Project No. 21101

**Re: PA22-024- Marysville 44th PRD – Technical Review 2
7315 / 7417 44th St NE – APN(s) 30053500303700 / 30053500303600**

This letter is provided as response to comments dated November 7 and November 8, 2022. Each item has been carefully reviewed and considered and the following is a summary of how each item was addressed.

L-1
SHEET 1 of 5

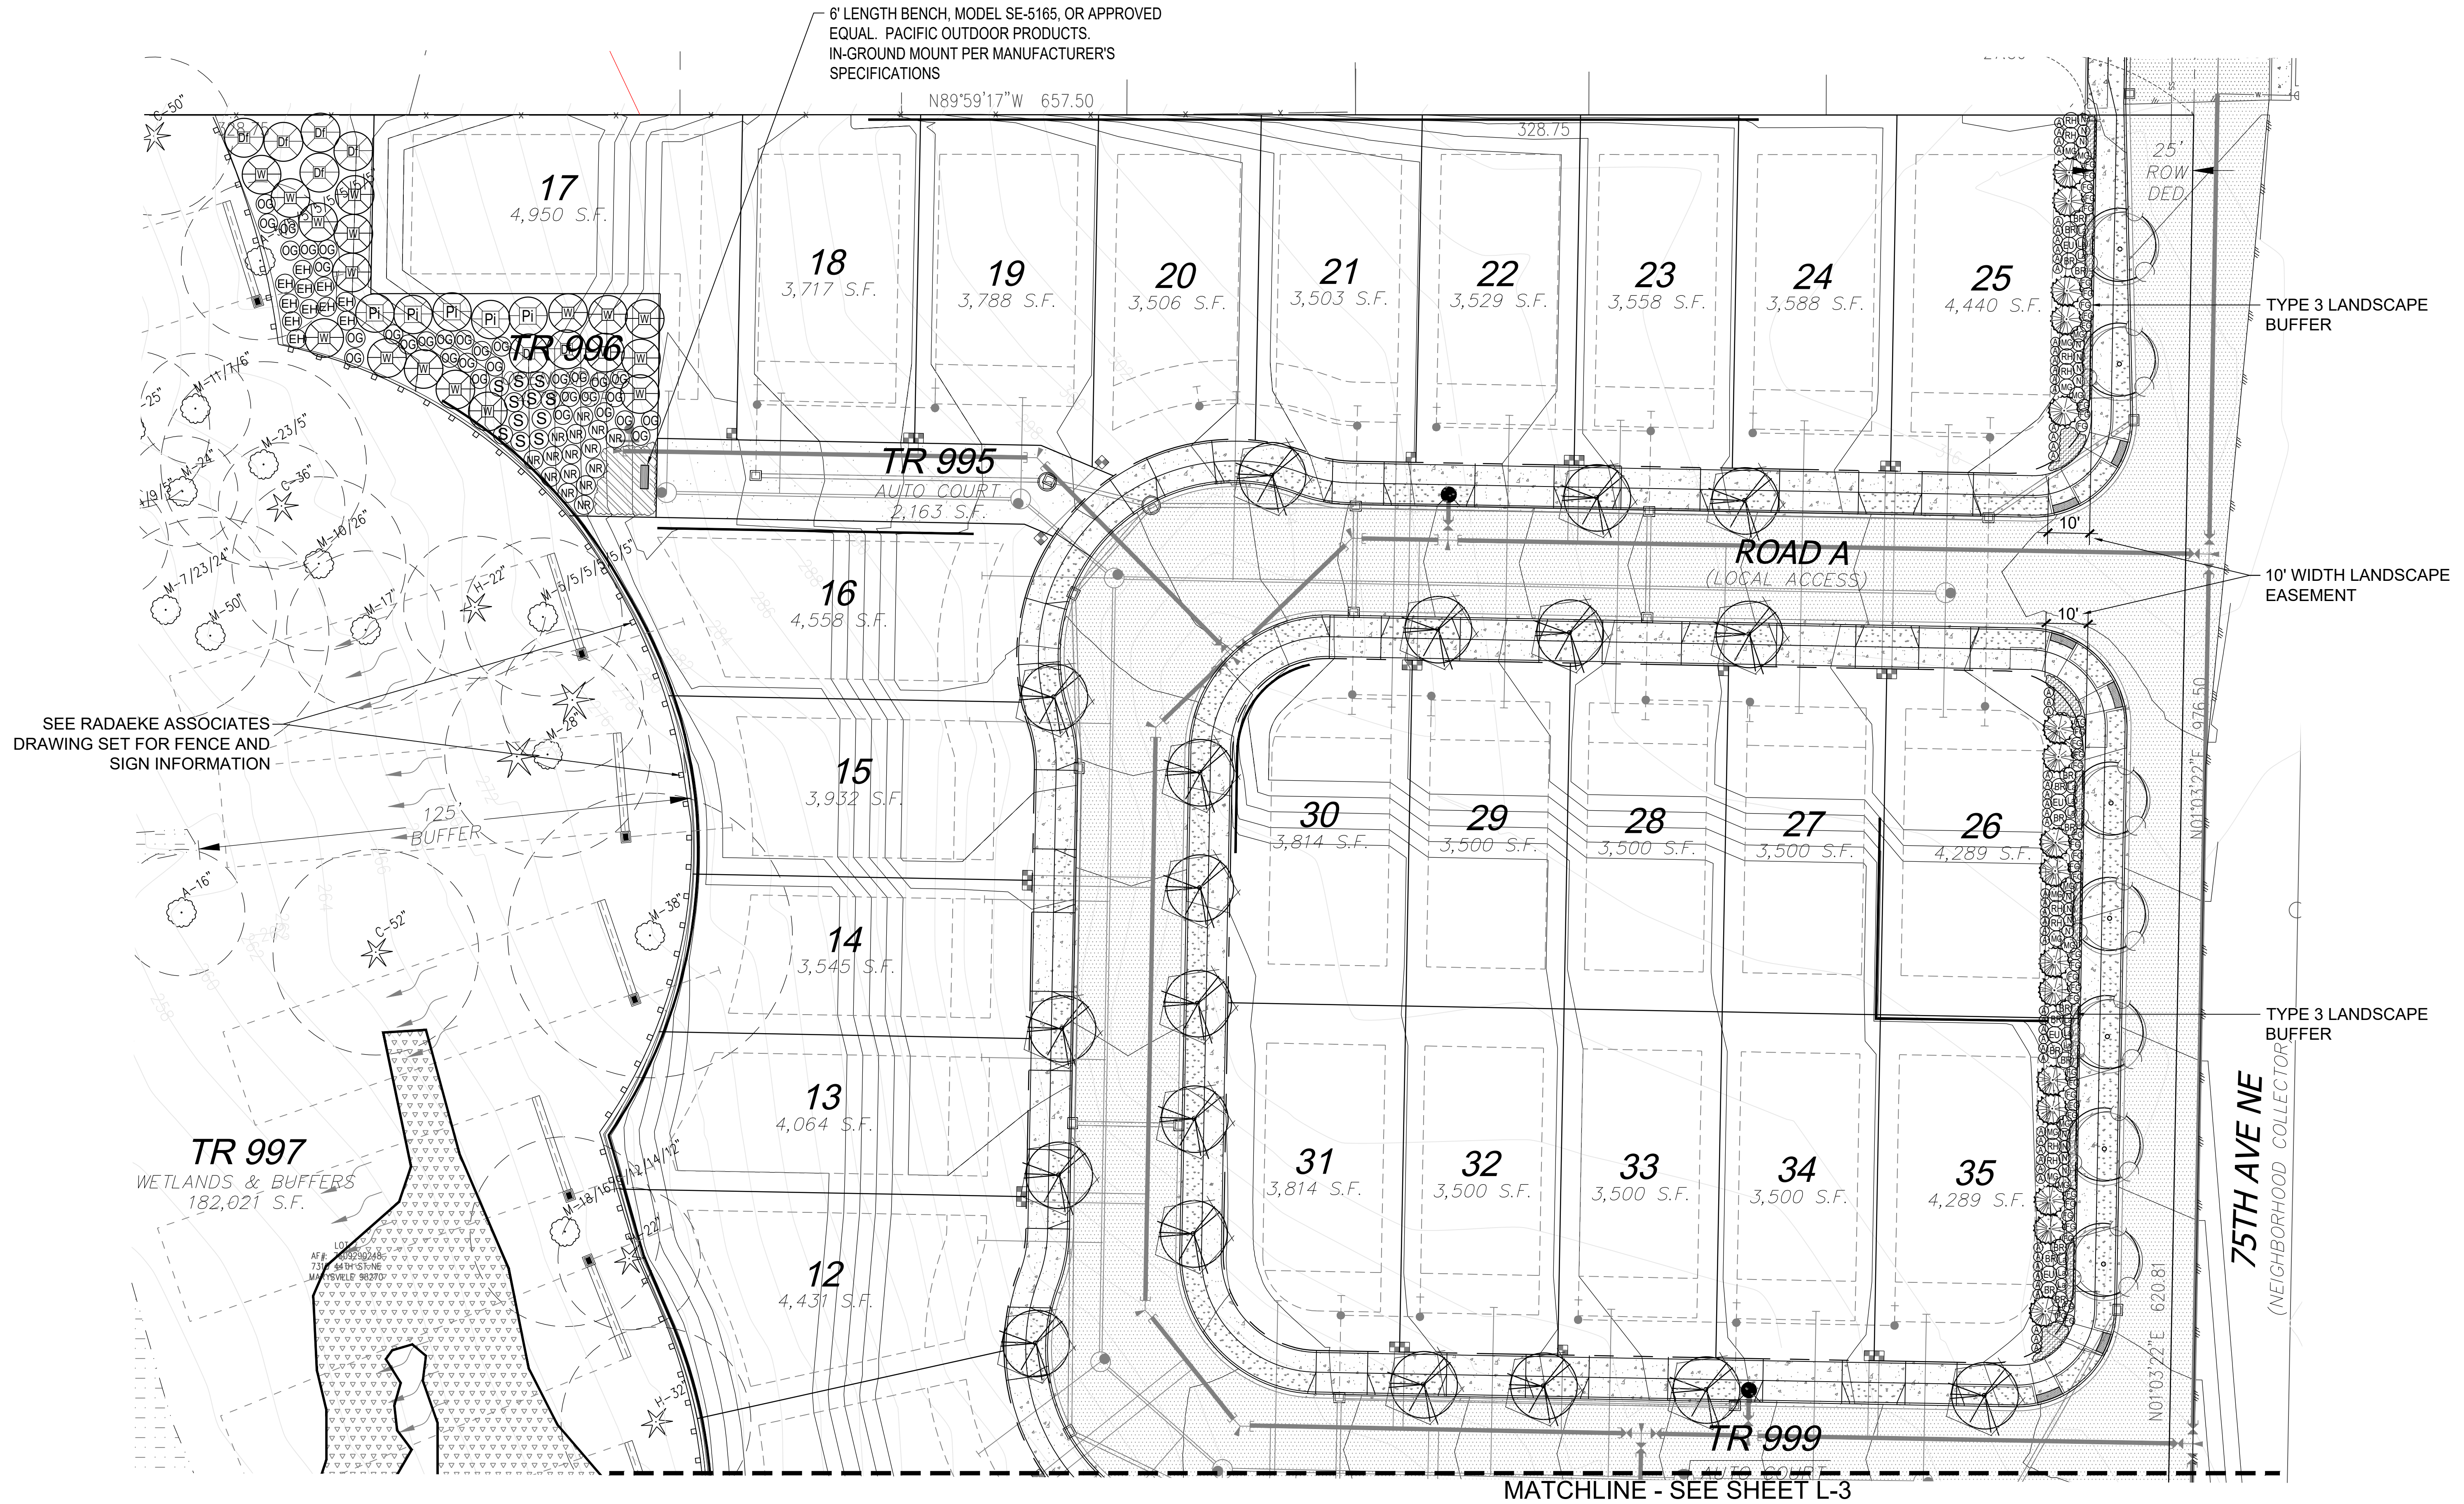
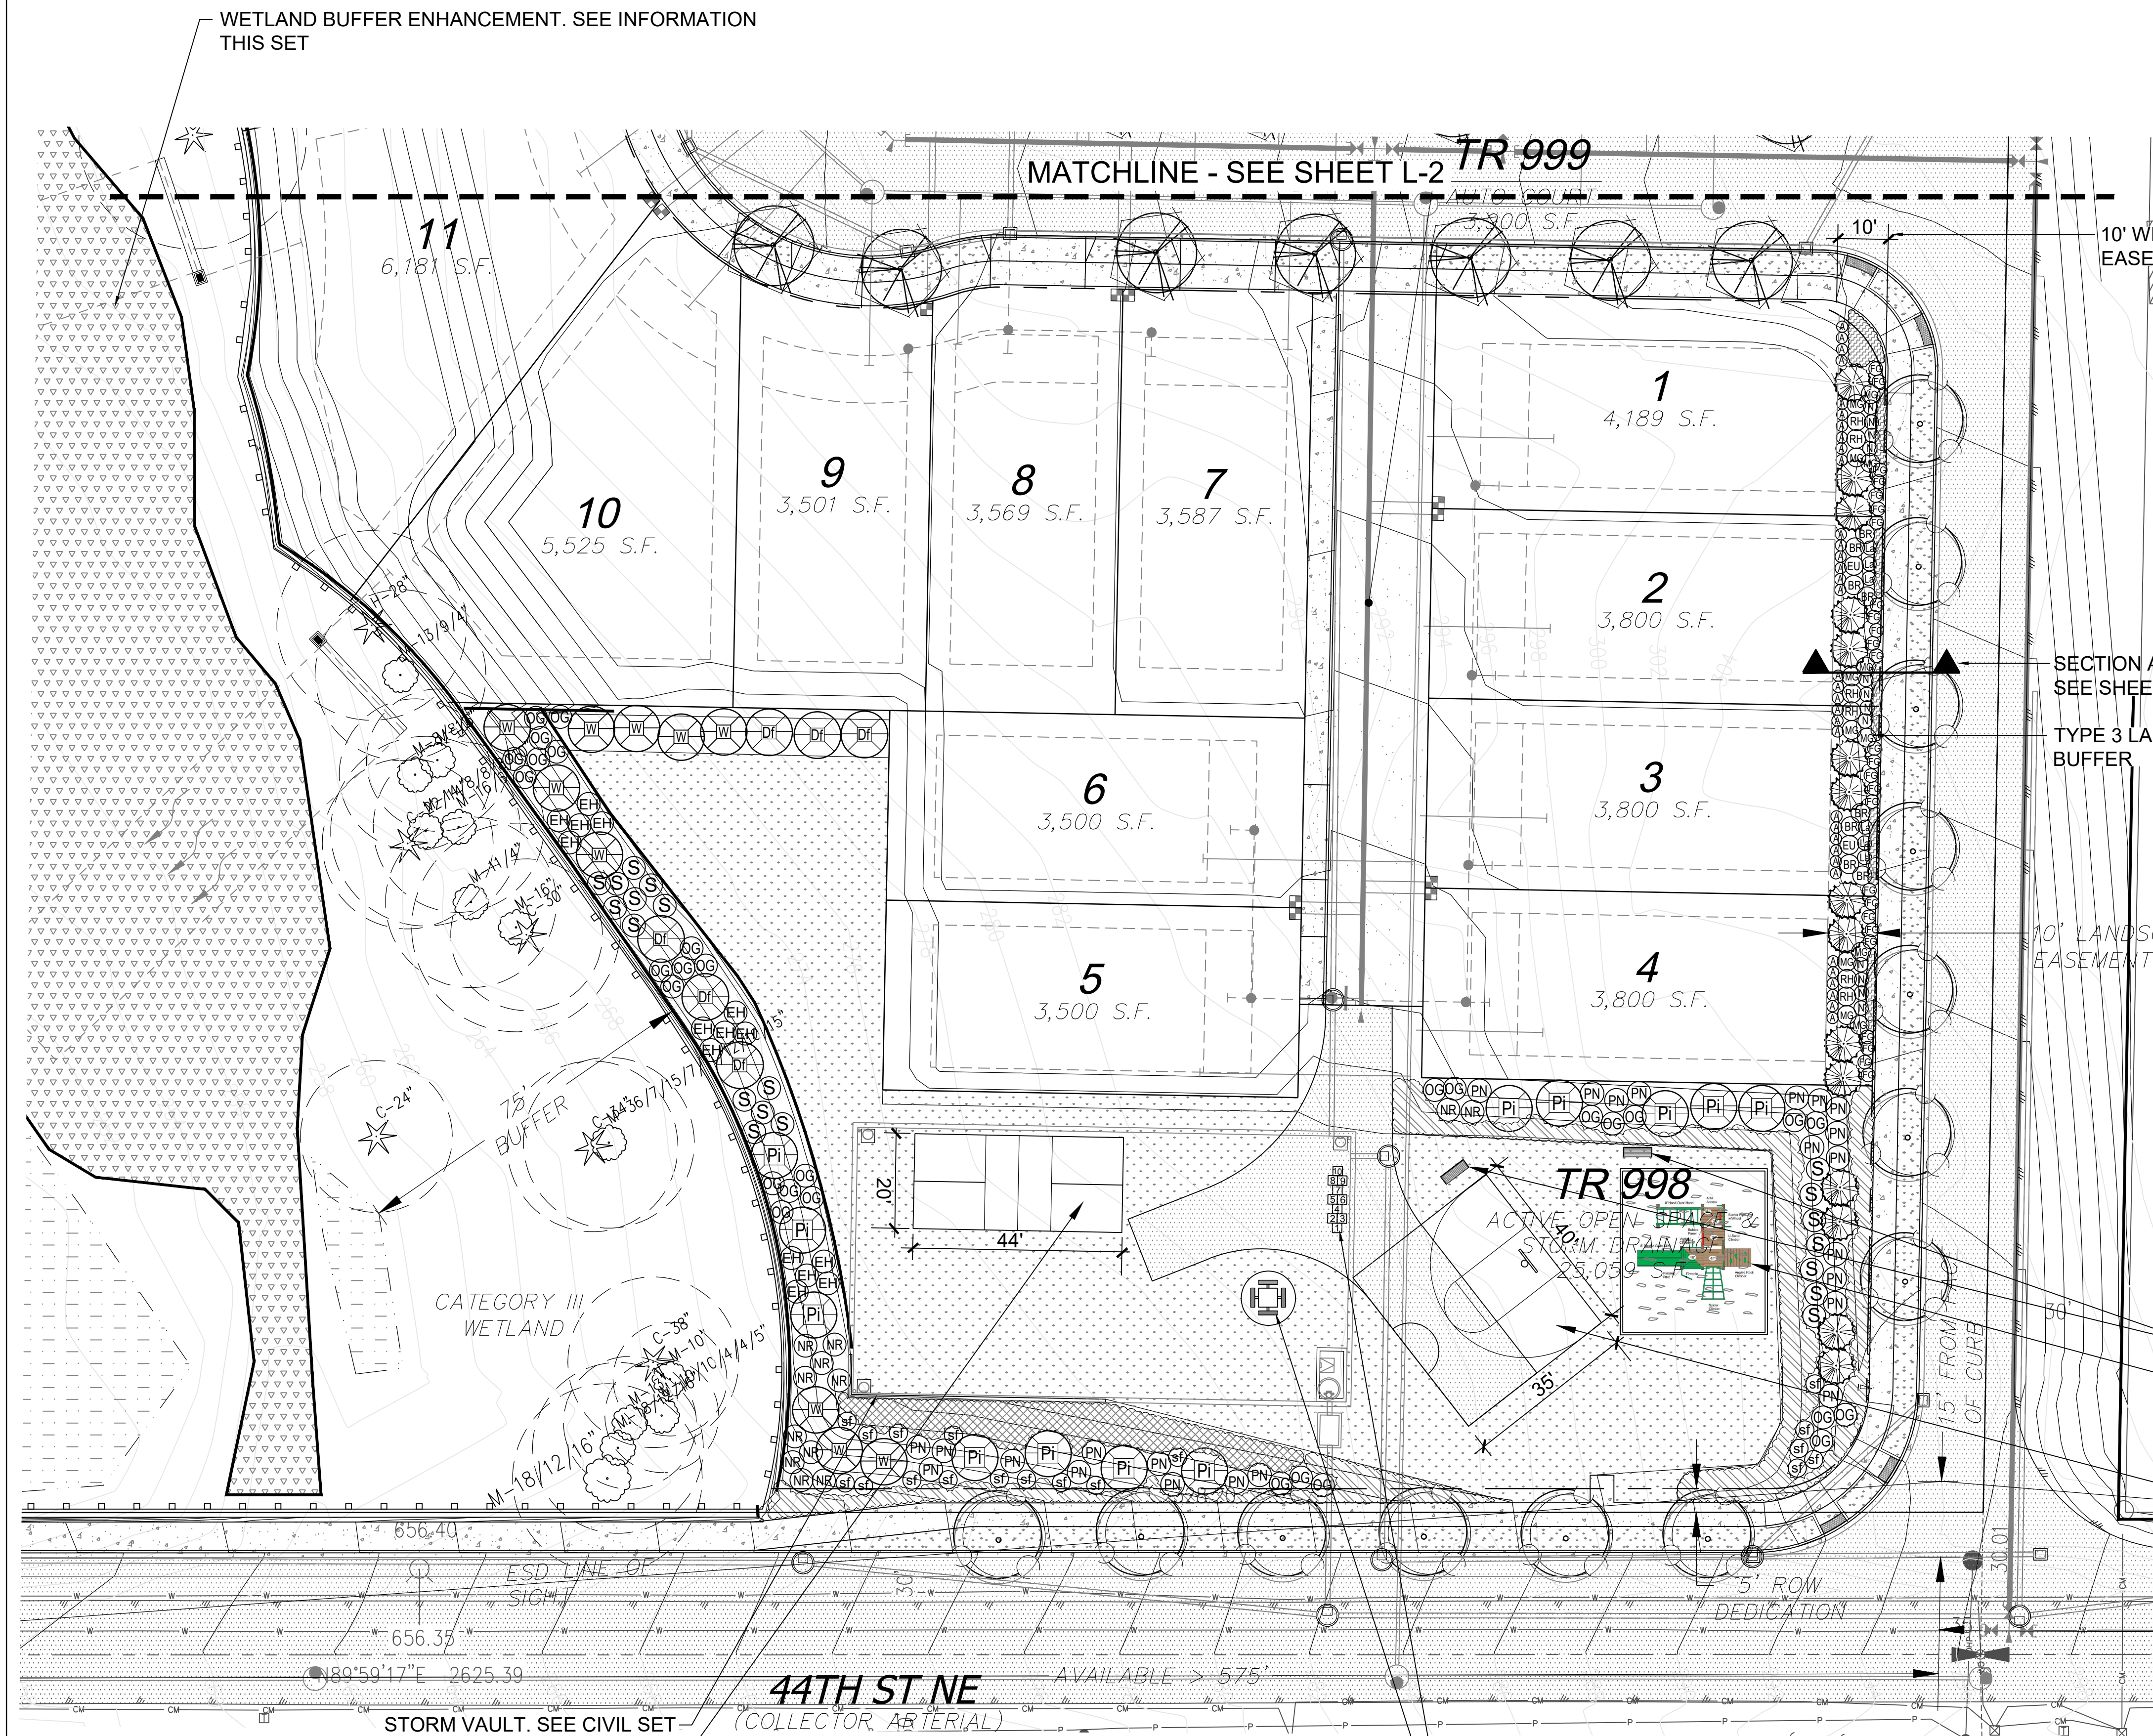
5. A final landscape plan shall be required to be approved prior to civil construction plan approval, and designed to comply with the applicable provisions outlines in MMC 22C.120, Landscaping and Screening. Specifically, please revise the Landscaping Plan to include:

5.1. Incorporate the mitigation planting plan prepared by Raedeke Associates, Inc. to allow for a cohesive planting plan for the proposed development.

5.2. Rather than dedicating (2) basketball courts in the active open space tract, a multipurpose sport court, tennis court, or similar should be included.

The revised landscaping plan provided now incorporates and references the mitigation planting plan. The active open space tract now includes a pickleball court instead of one of the basketball courts.
